July 29, 2005

**RE: OFFICE BUILDING @ 802 LOMAS BLVD. N.E. (J14-D94)**

This letter is in response to your comment letter dated July 7, 2005:

GRADING & DRAINAGE PLAN

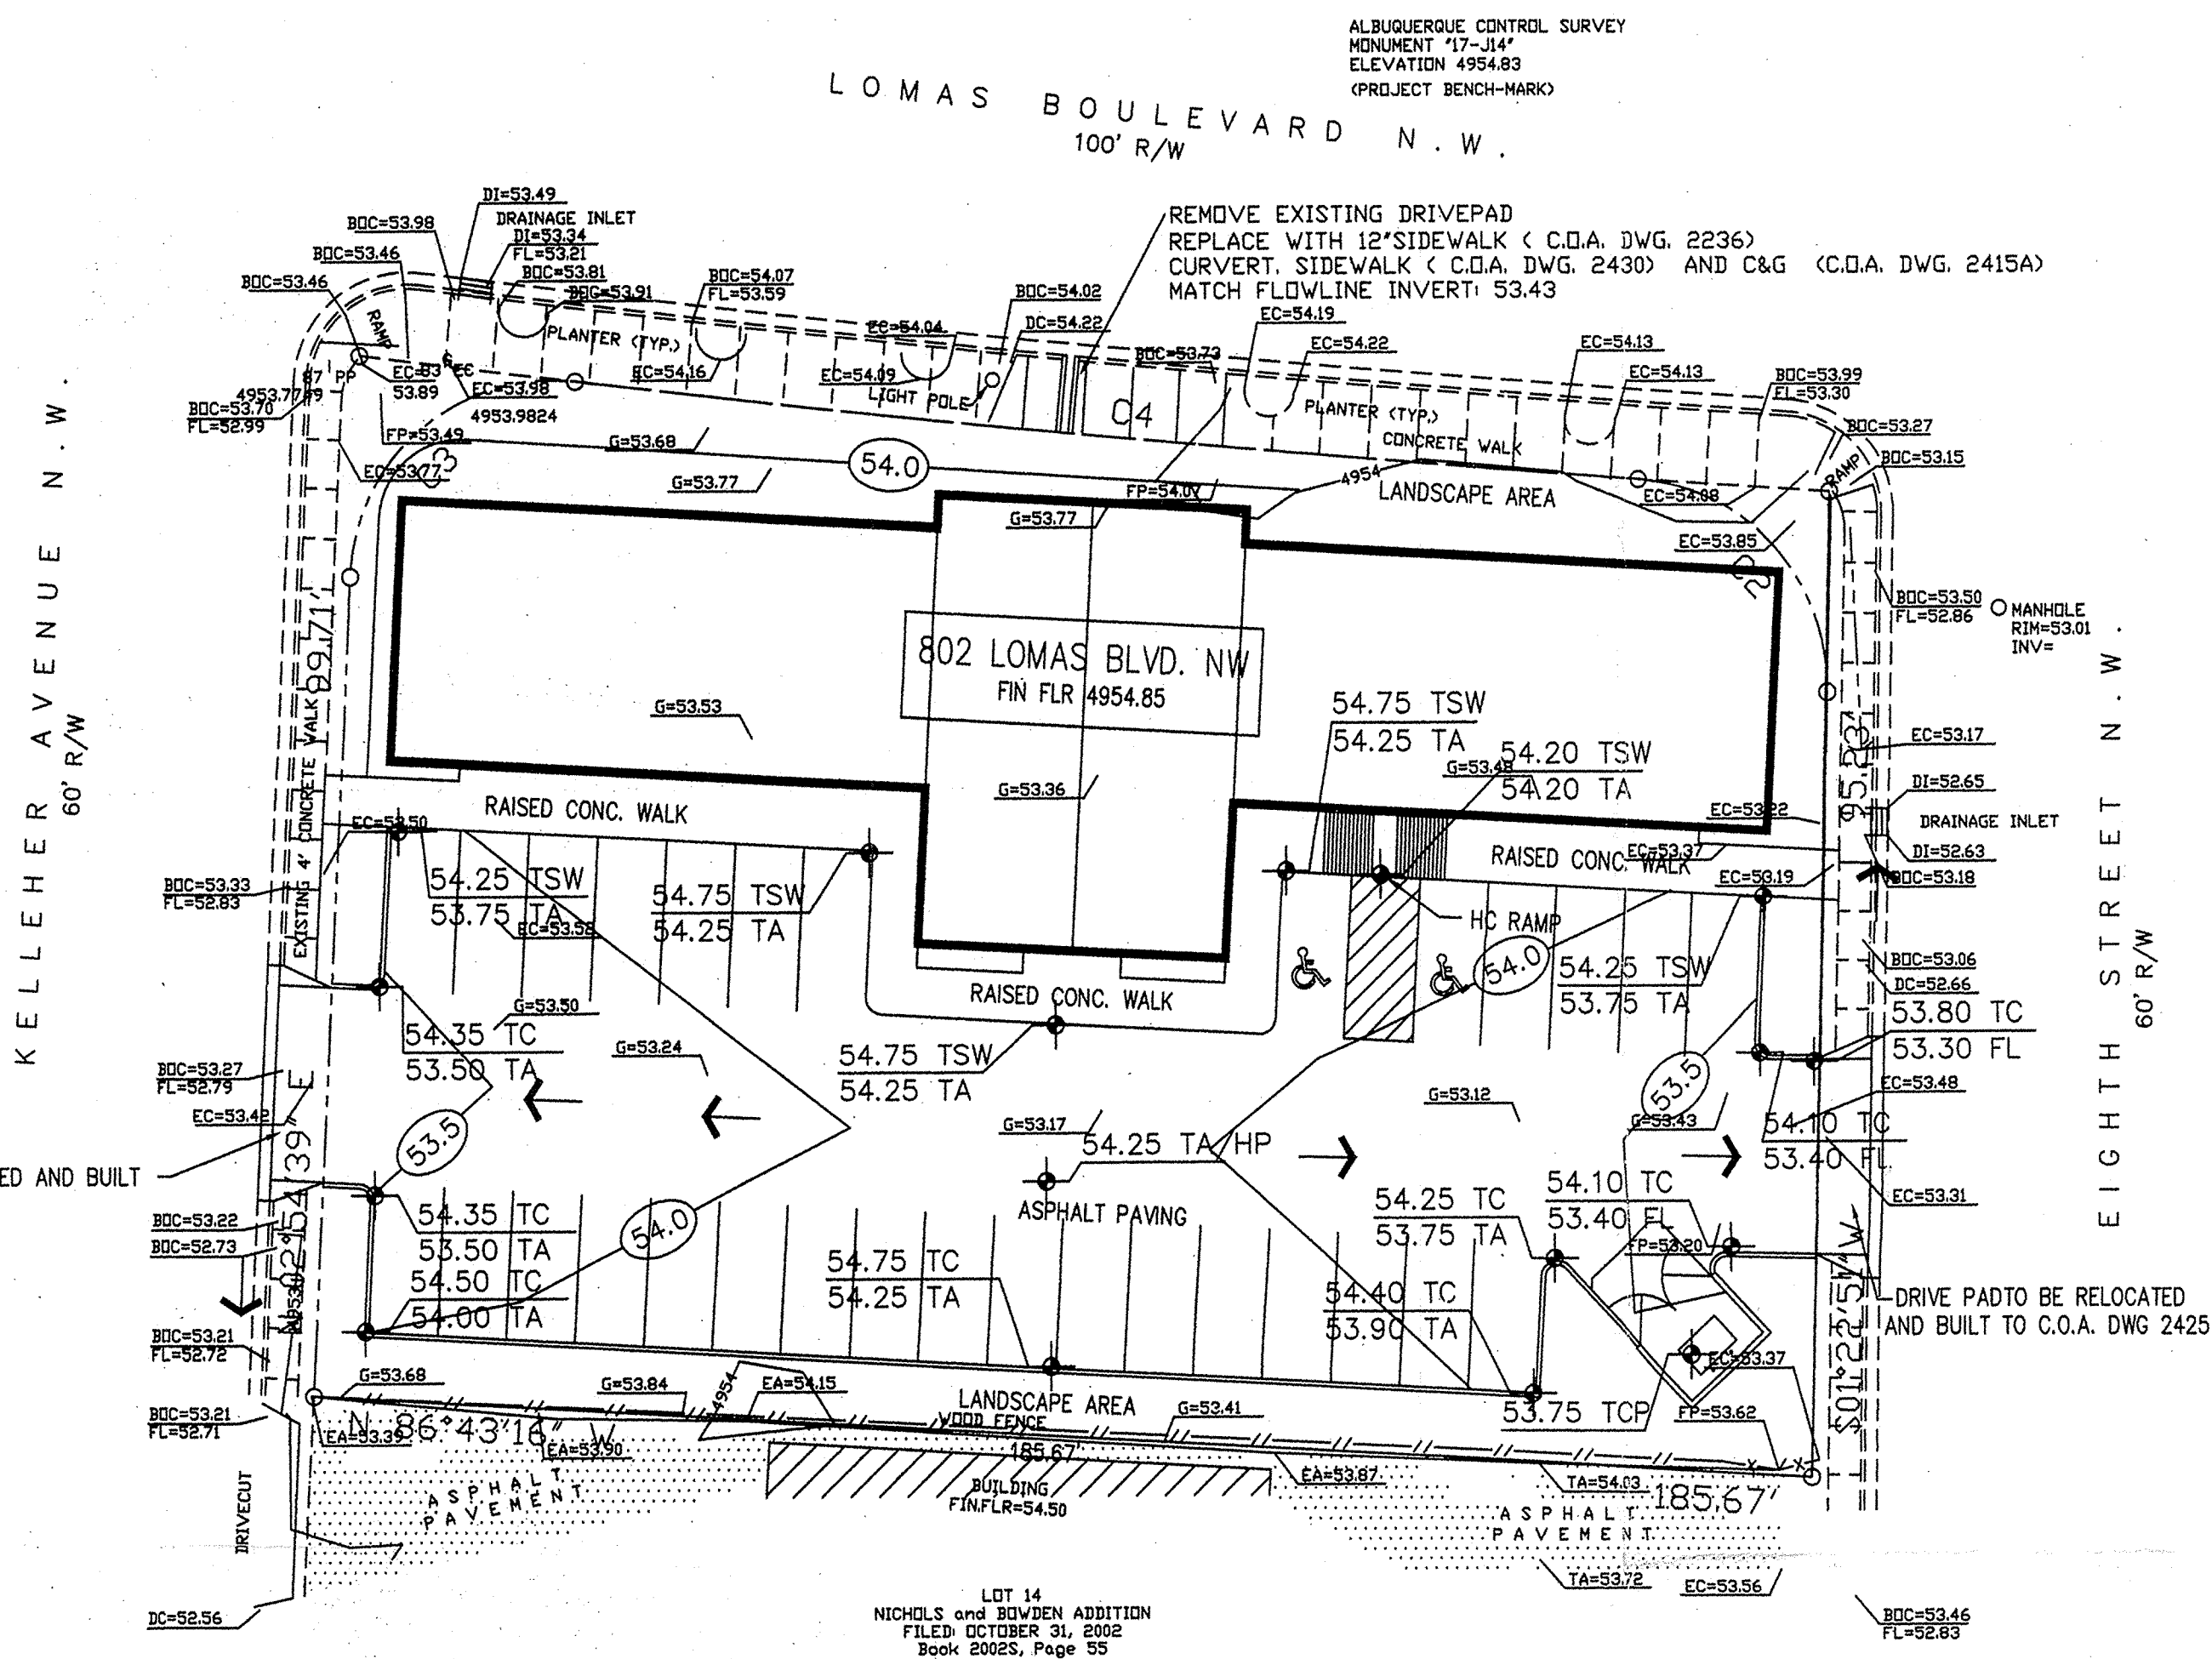
1. Provide inverts for the proposed sidewalk culvert. *Invert has been providing on the plan drawing.*
2. Call out City of Albuquerque Standard Drawings for the proposed sidewalk culvert, sidewalk and curb and gutter. *City standard spec. Numbers are shown on the plan drawing.*
3. Verify flow direction along Kelleher Avenue. *Flow arrow has been rotated to indicate the correct flow direction on Kelleher Avenue. Included is a schematic of the existing infrastructure in the area. The developed flows will enter the existing catchbasin at the intersection of Kelleher and fruit Avenue.*
